**Fwd: 31 Cedar St., BP#2017-01905 plan review comments - Reviewed**

Subject: 31 Cedar St., BP#2017-01905 plan review comments - Reviewed

PROJECT NAME: OXFORD ST. SHELTER BATHROOM
 PORTLAND MAINE
 SHEET NAME: FIRST FLOOR PLAN

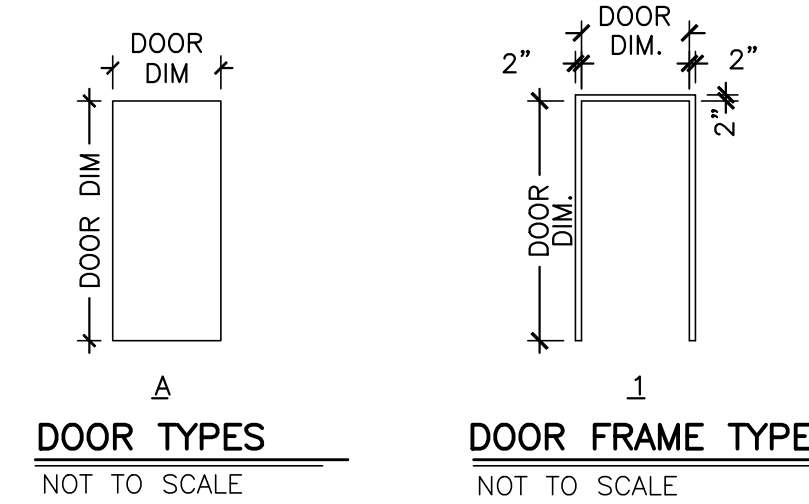
1. Sheet A1 Comment: *The WC clearance requirement is 24", this is not achieved by 51"- 28.25" toilet length = 22.75". As a compromise between this and the 3' passage, please adjust for a 4'-4" stall length and 2'-11" passage width.*

As per compromise, adjustments have been made on A1 sheet.

PROJECT NAME: OXFORD ST. SHELTER BATHROOM
PORTLAND MAINE
SHEET NAME: ELEVATIONS

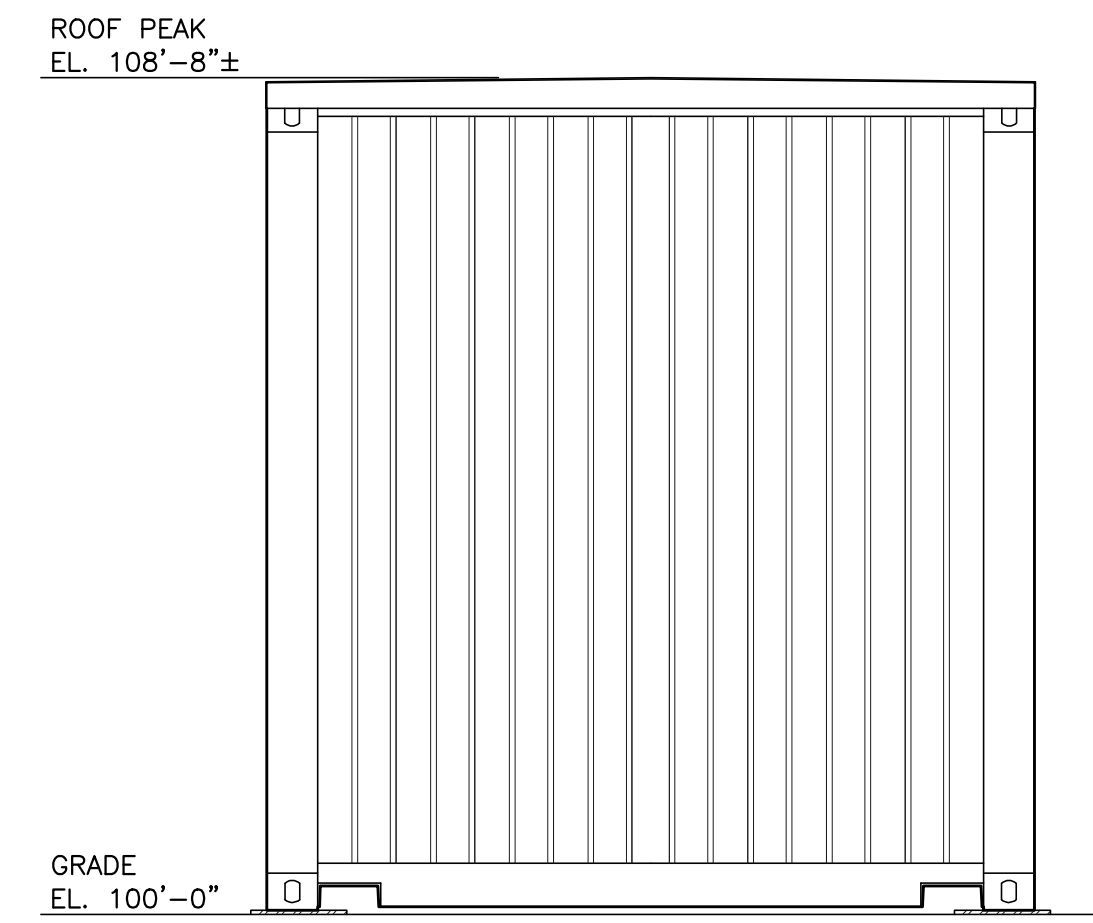
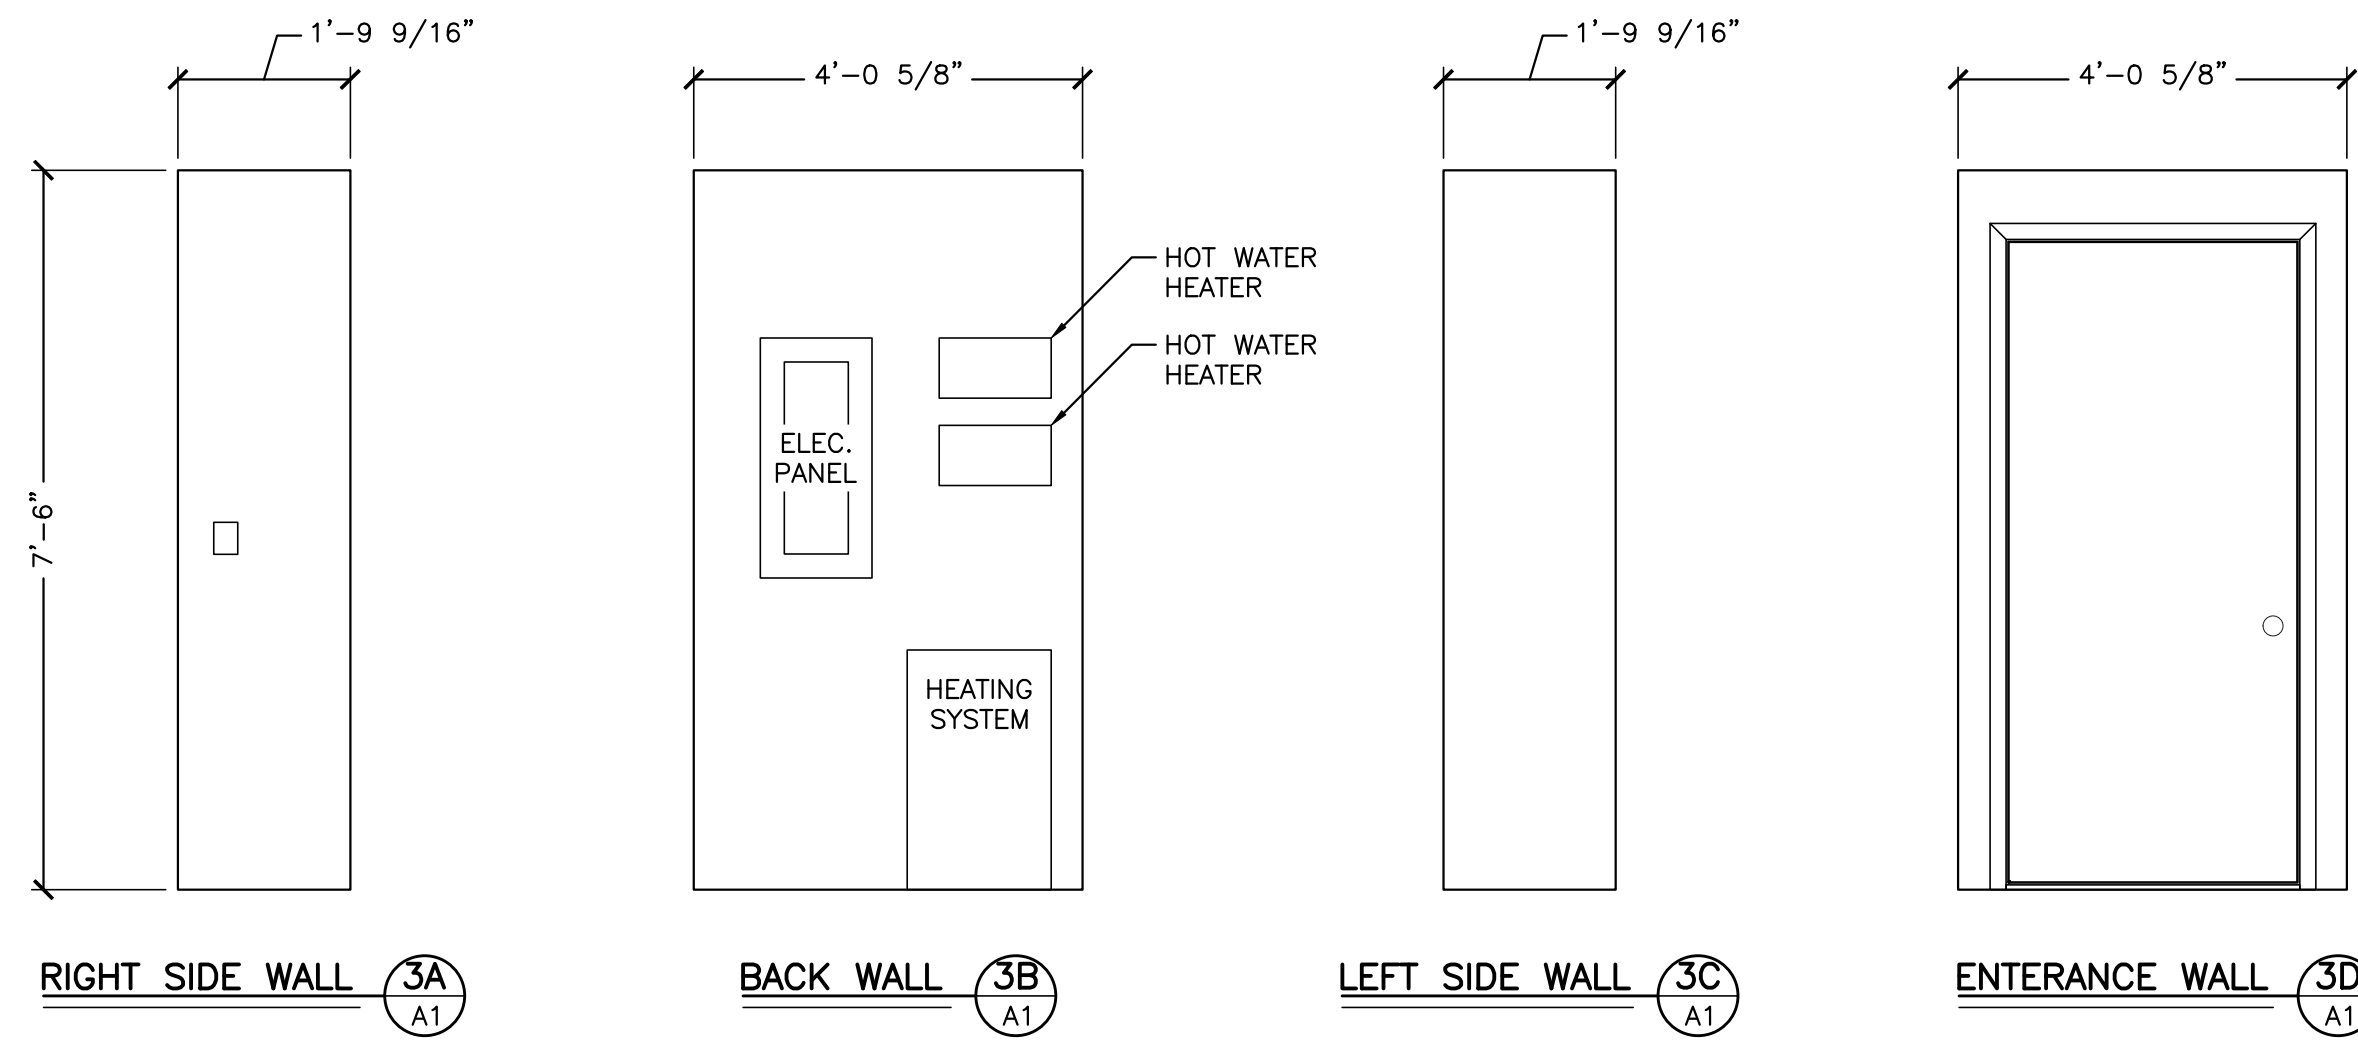
2. Sheet A2 Comment: *Please provide a plan view of the exterior wall framing details including studs, corrugated wall panel, insulation and total dimensional thickness.*

Plan view of exterior walls are dictated by wall types on Sheet A1. Containers are pre-manufactured and are slightly different from each manufacture. A physical piece of container was given to make structural details for door & windows, Sheet A2 Detail 4 & 5. Container construction is not like regular construction, they are pre-manufactured.

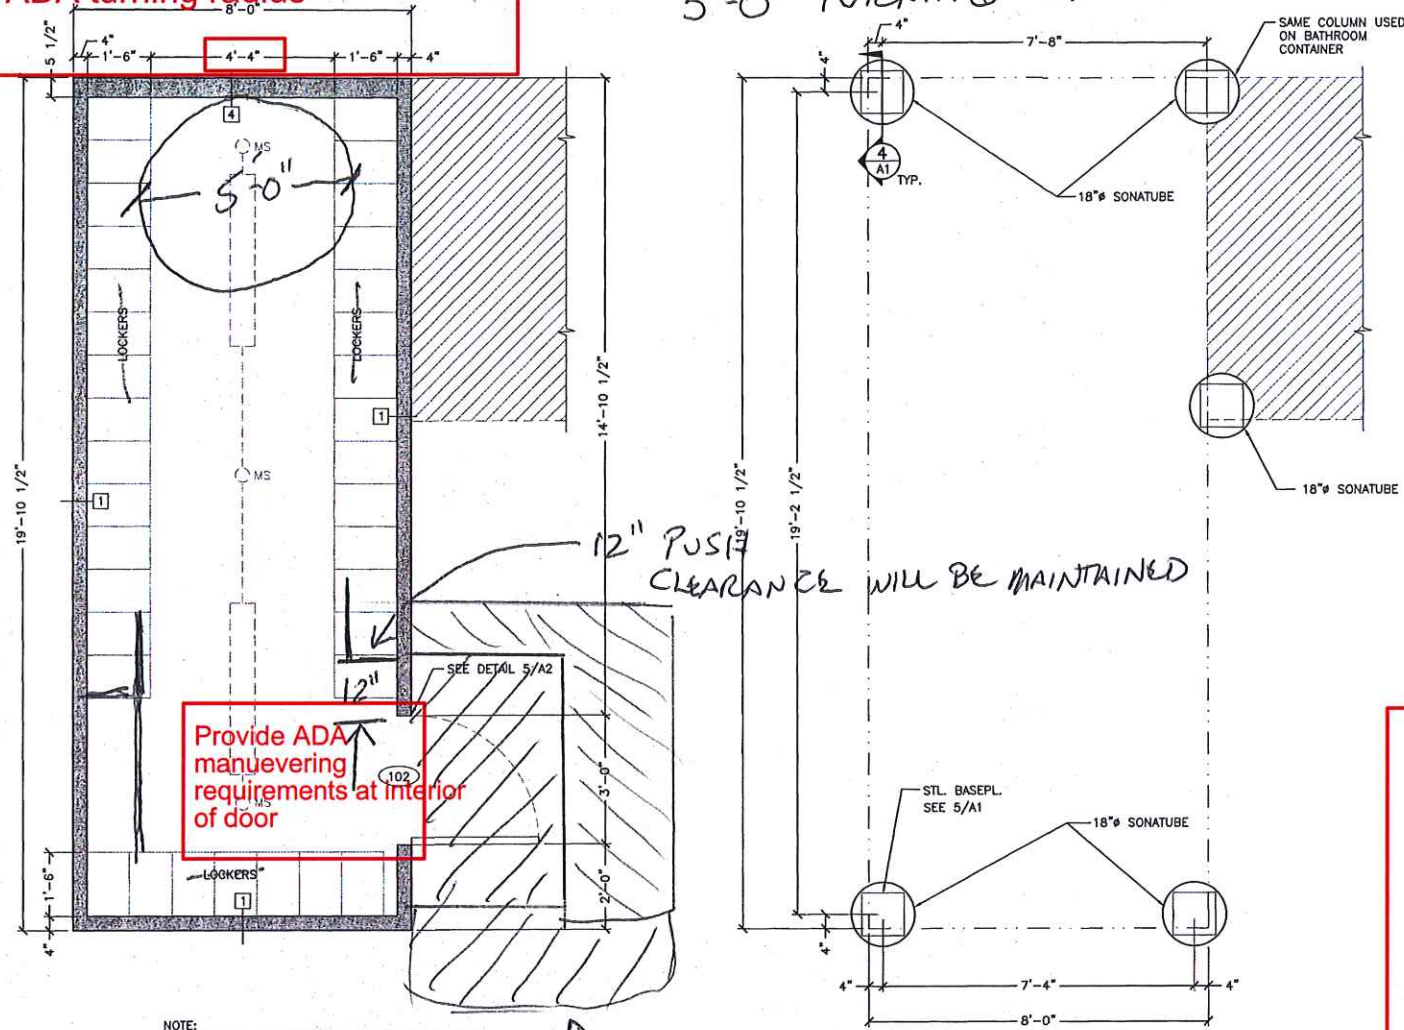
3. Sheet A3 Comment: *Please provide a plan view and elevation of the ramp & landing with all required ADA elements including maneuvering clearances, dimensions, railings, edge protection, slope etc.*

See general notes on Sheet A1, **Note 11. Design for bathroom and locker container does not meet 2010 ADA standards requirements at owners request.**

Ramps and landscaping are to be done by others. Finish locker installation is done by others.

FLOOR PLAN 1
SCALE: 1/2" = 1'-0" P1

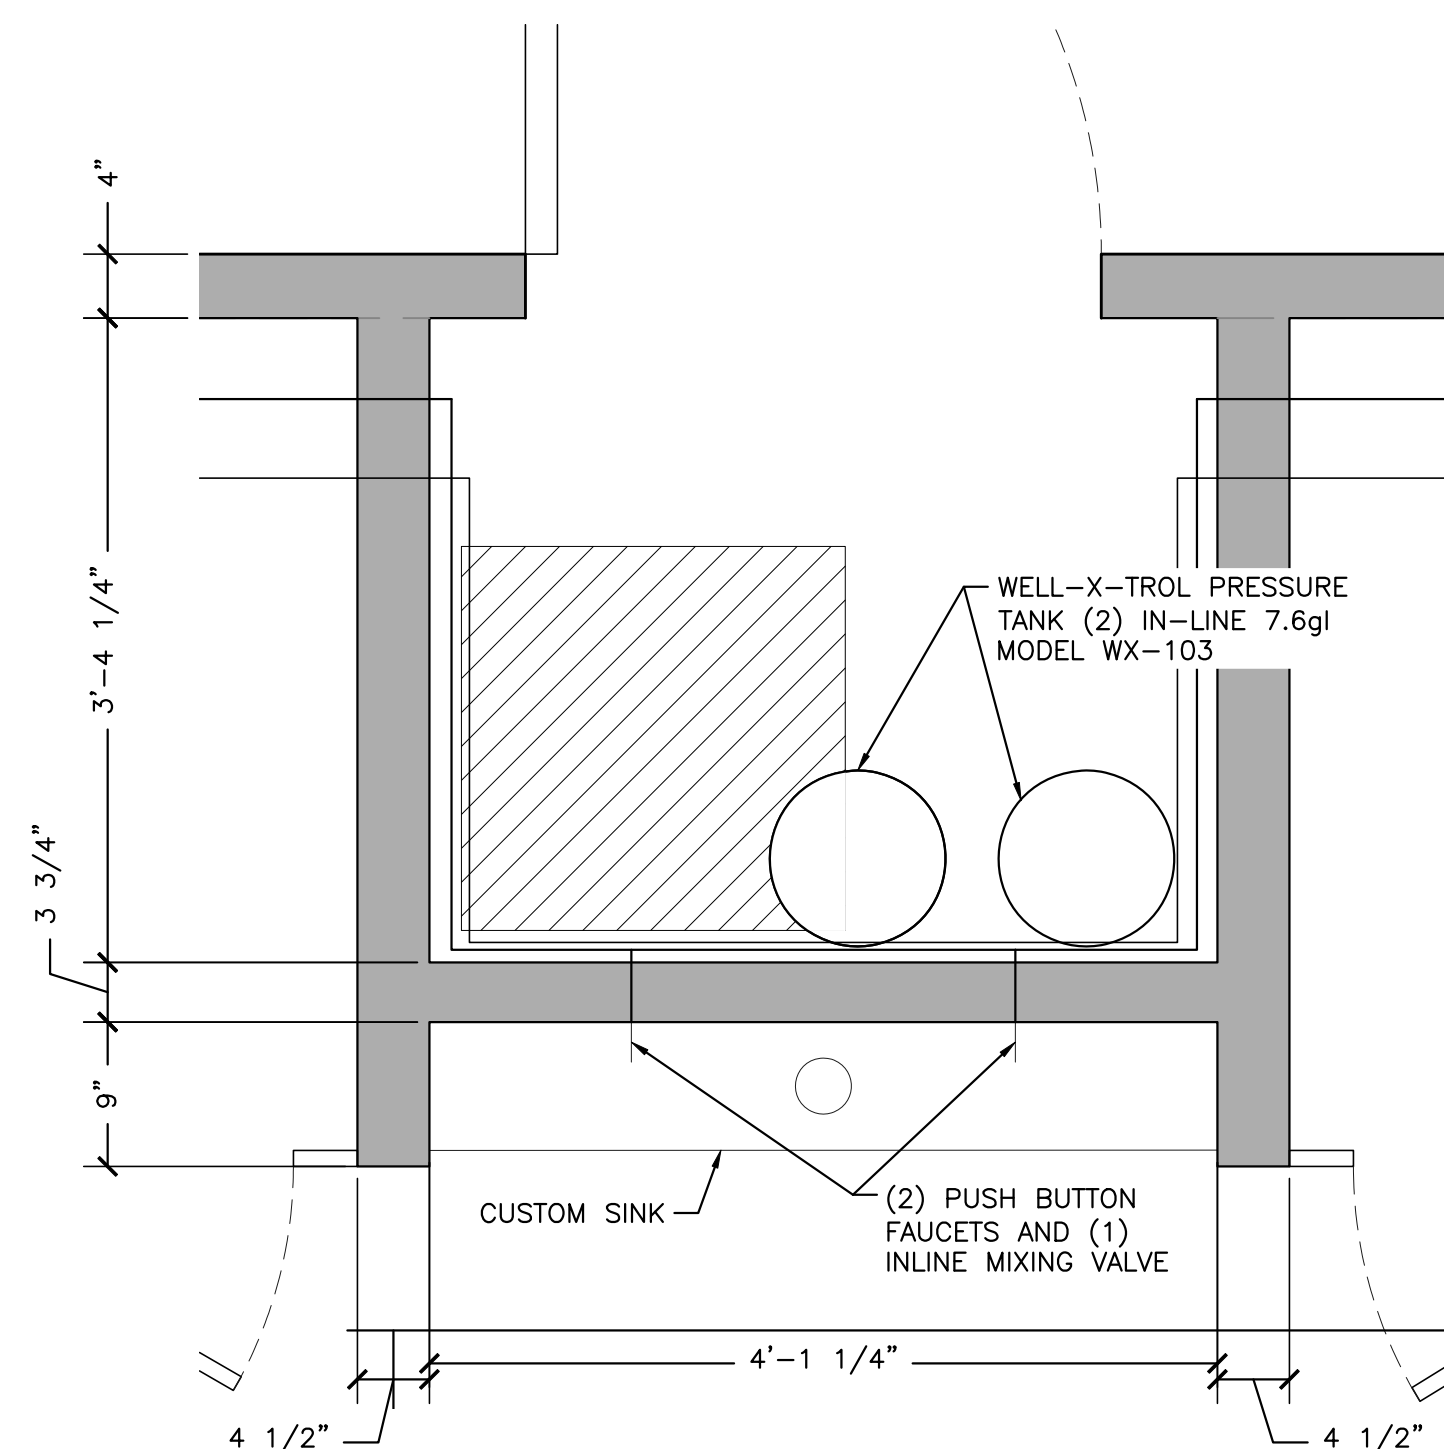
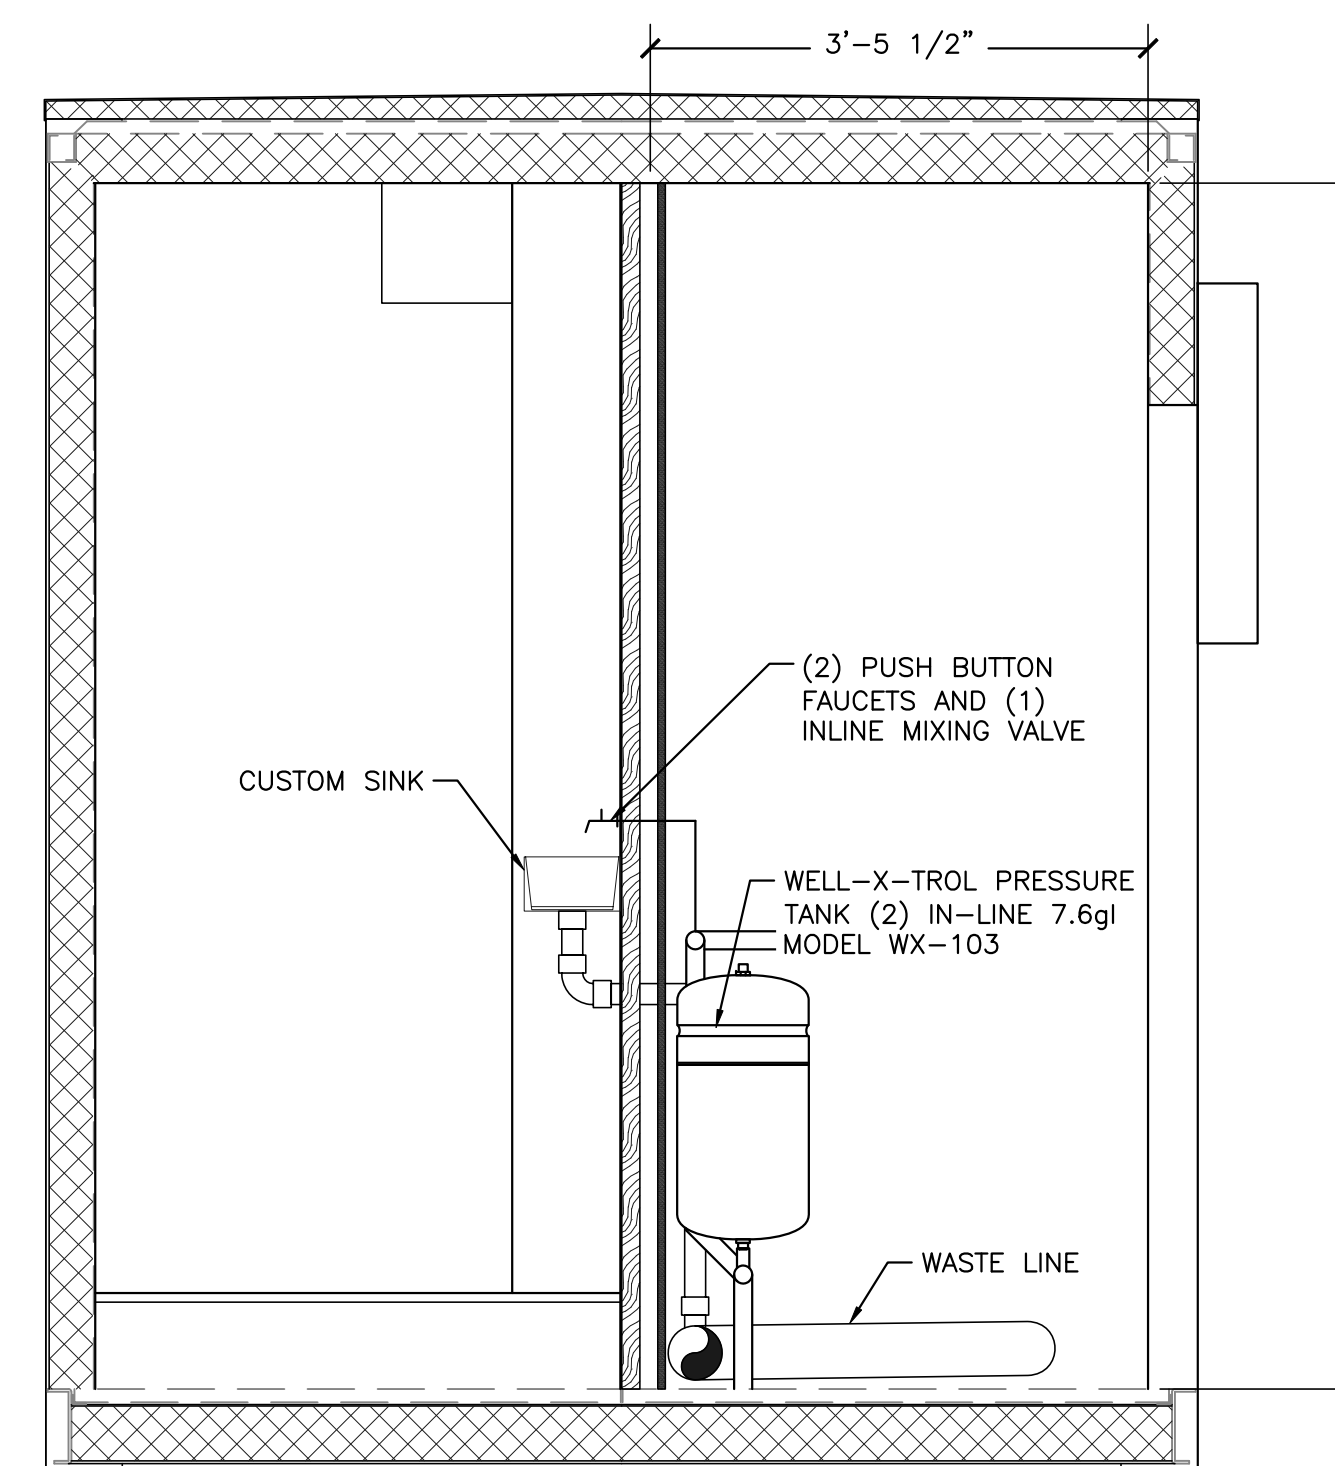
We still need a revised plumbing and mechanical plan. Please make sure that the venting is shown on the plumbing.
